CITY OF ALBUQUERQUE

August 19, 2024

RE: 2103 Los Luceros Rd. NW
Grading and Drainage Plan
Engineer's Stamp Date: 6/17/24
Hydrology File: H12D025

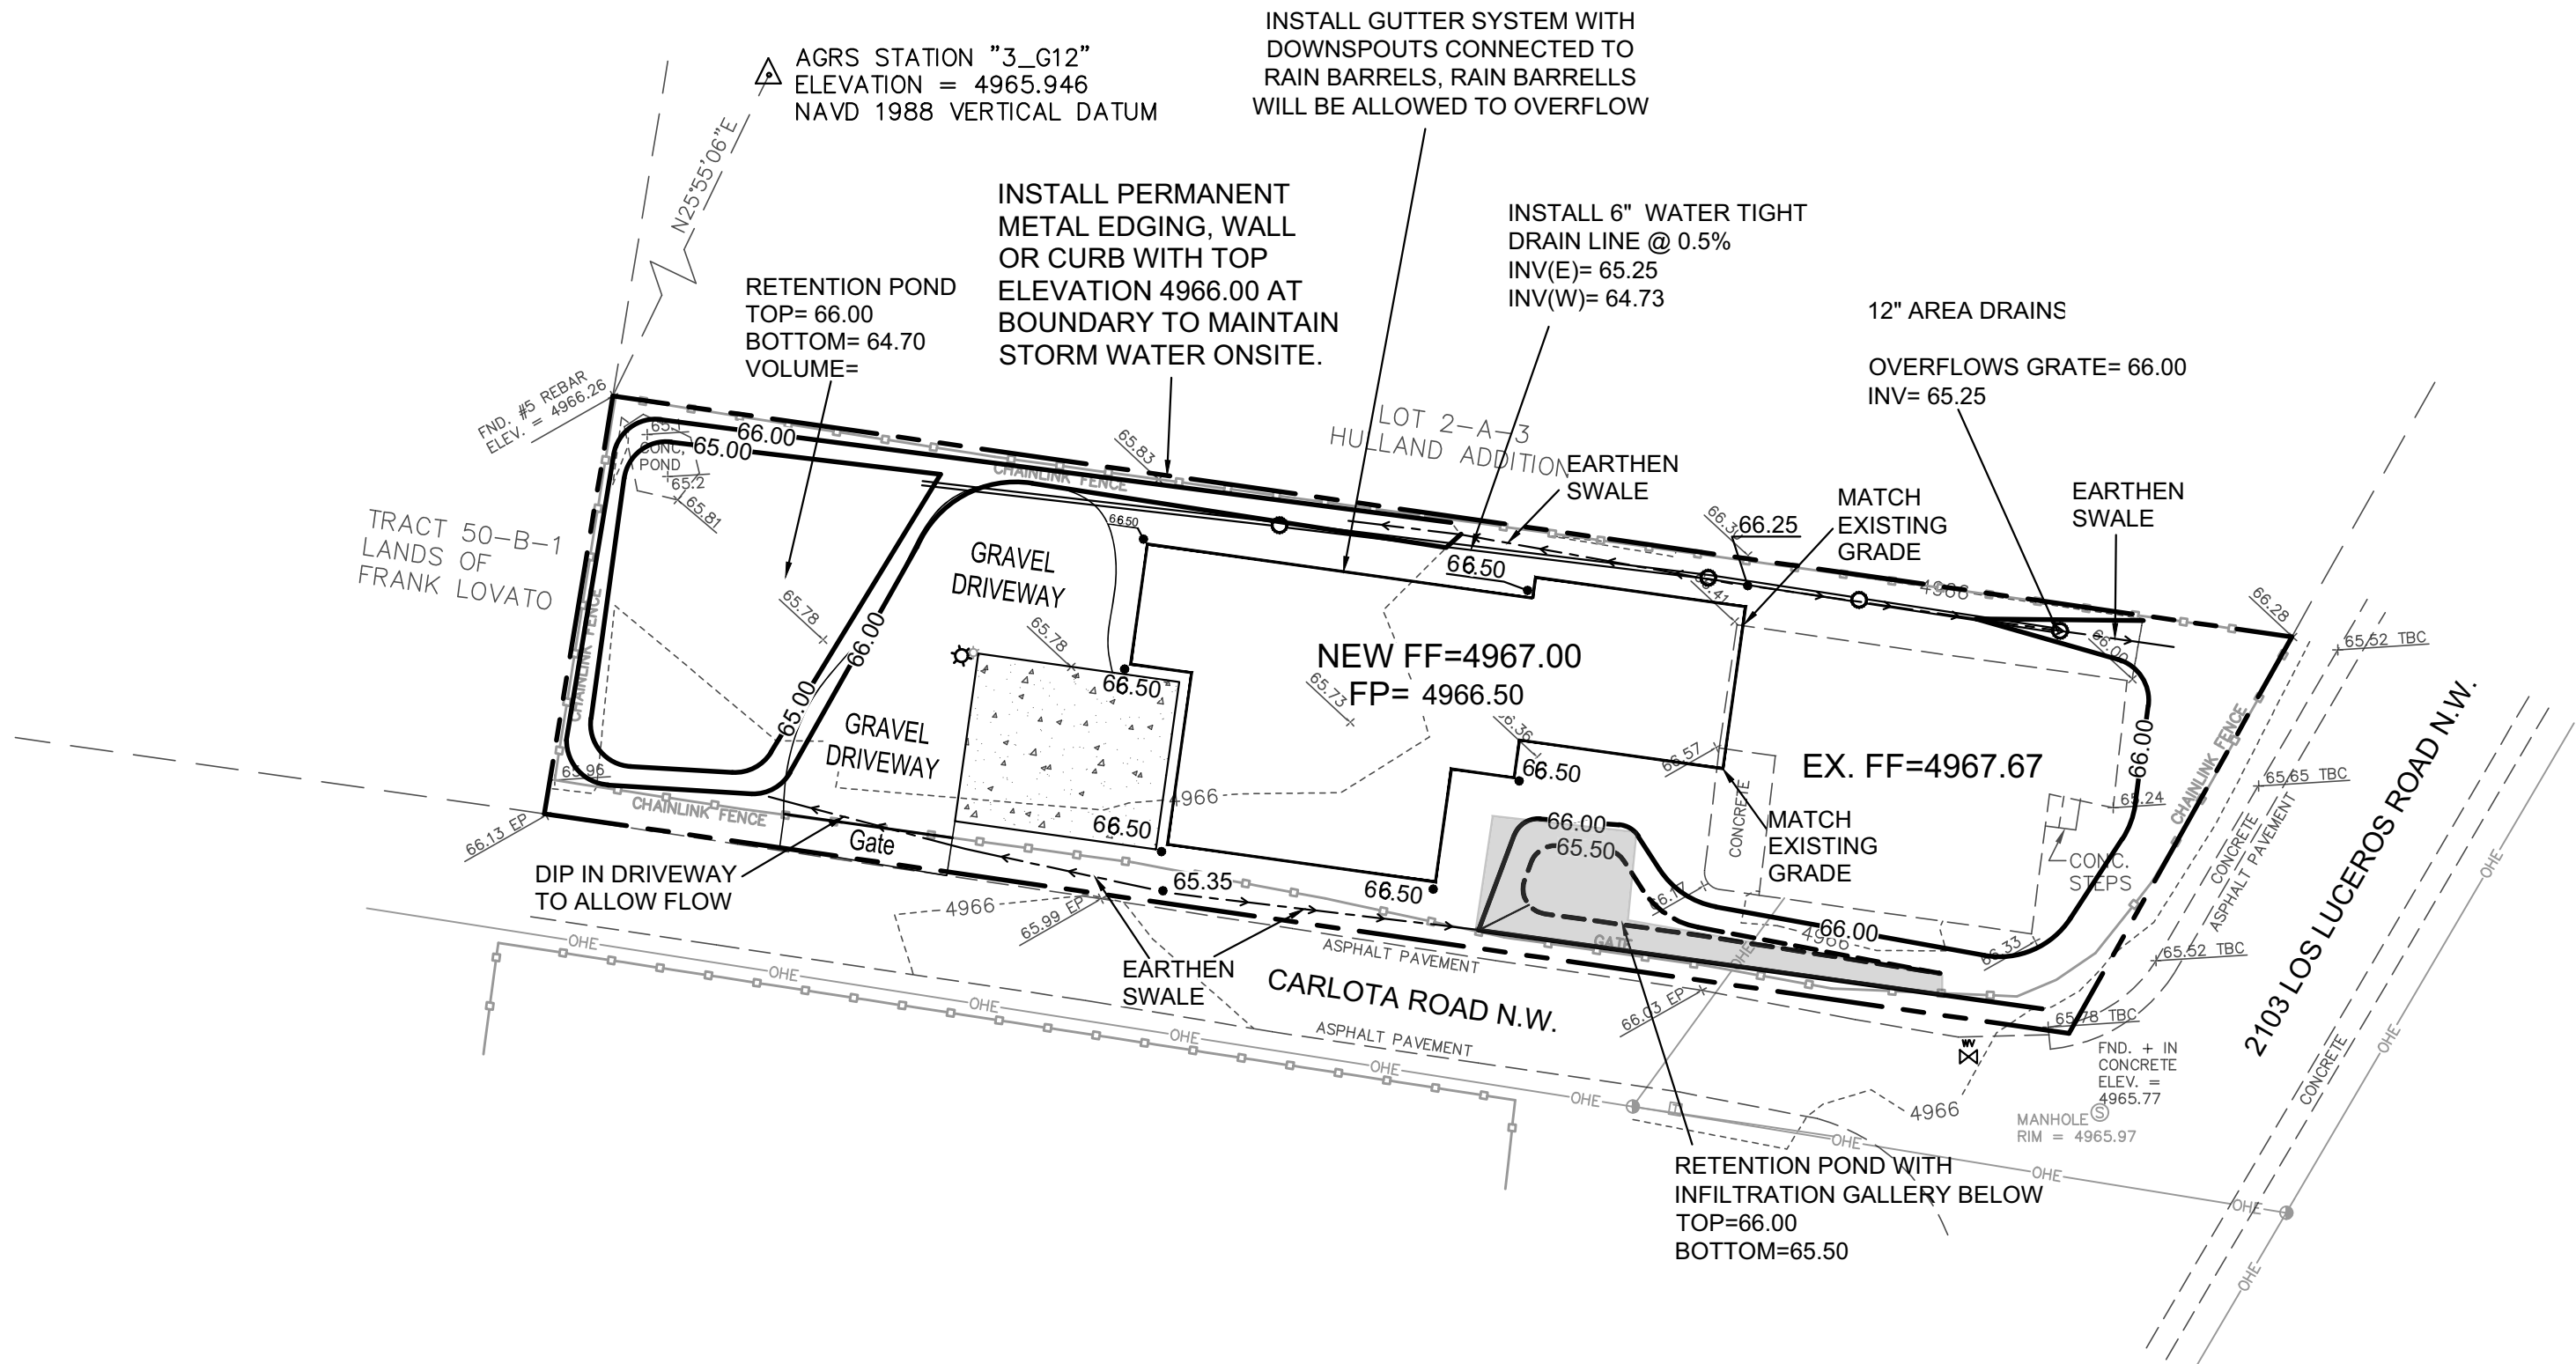
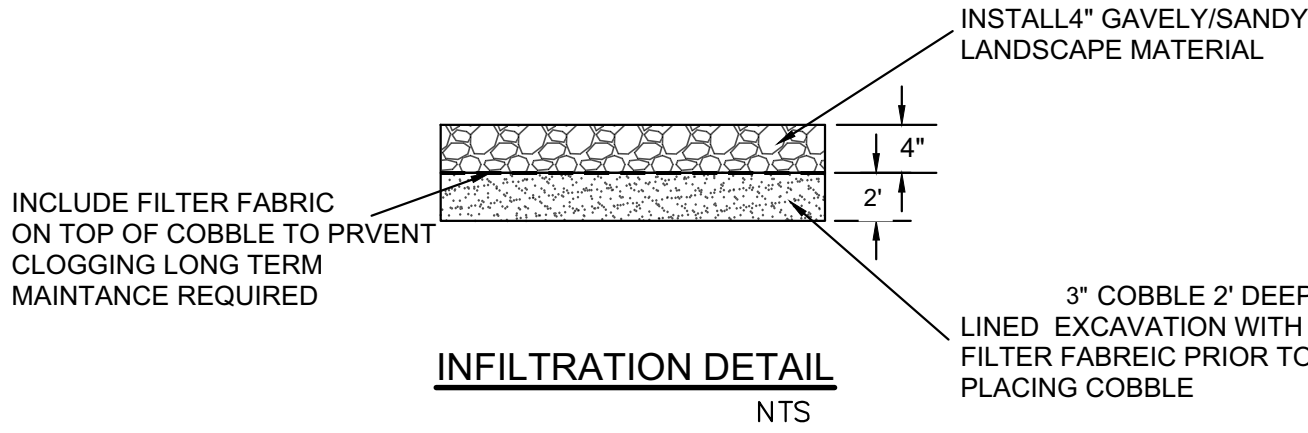
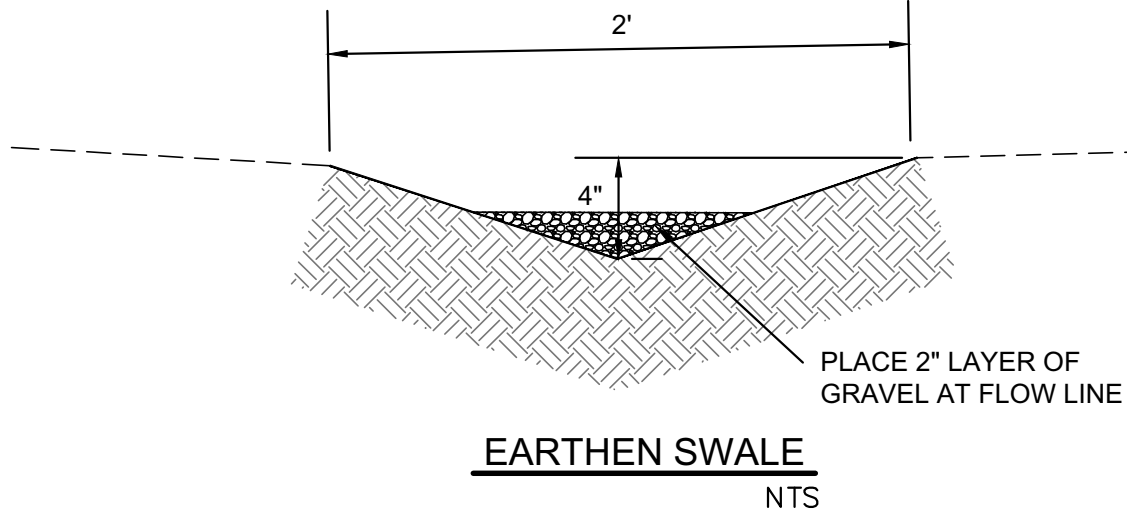
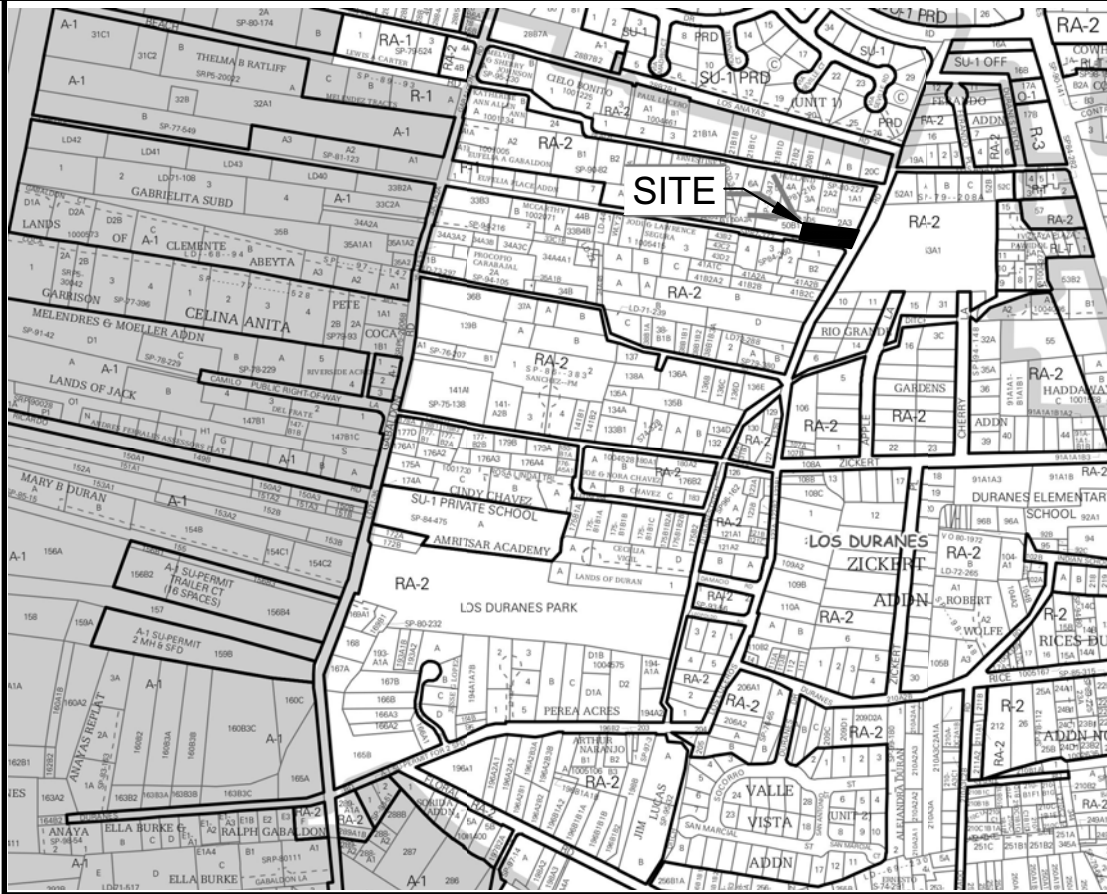
1. For review and recording purposes, the font size of the Weighted E Method information block should be at least the same font size as the EROSION CONTROL NOTES. **YES**

2. The narrative information below the Weighted E Method calculations appears to be cut off and should be reviewed for accuracy and clarity. The revised resubmittal should show the corrected and appropriate information. **YES**

3. The narrative states "The ponds will overflow to the adjacent lots and ultimately to the street in the event of a storm . . ." is not acceptable and the entire narrative should be reviewed and revised for accuracy, AND state that no storm water will adversely impact adjacent lots. **YES**

4. The scale as shown should be revised to 1" = 20' in a subsequent resubmittal. **YES**
5. Please provide the SWQV calculations on the plan. Provide management onsite for the Stormwater Quality Volume (SWQV) in accordance with the new drainage ordinance, § 14-5-2-6 (H). Please follow the DPM Article 6-12 Stormwater Quality and Low-Impact Development for the sizing calculations. To calculate the required SWQV, multiply the impervious area draining to the BMP by 0.26 inches for redevelopment sites. The calculations of both the required and the provided volume of each BMP must be shown on the Grading and Drainage Plan. **we have added but i dont believe they apply to this single family lot, unless it changed**
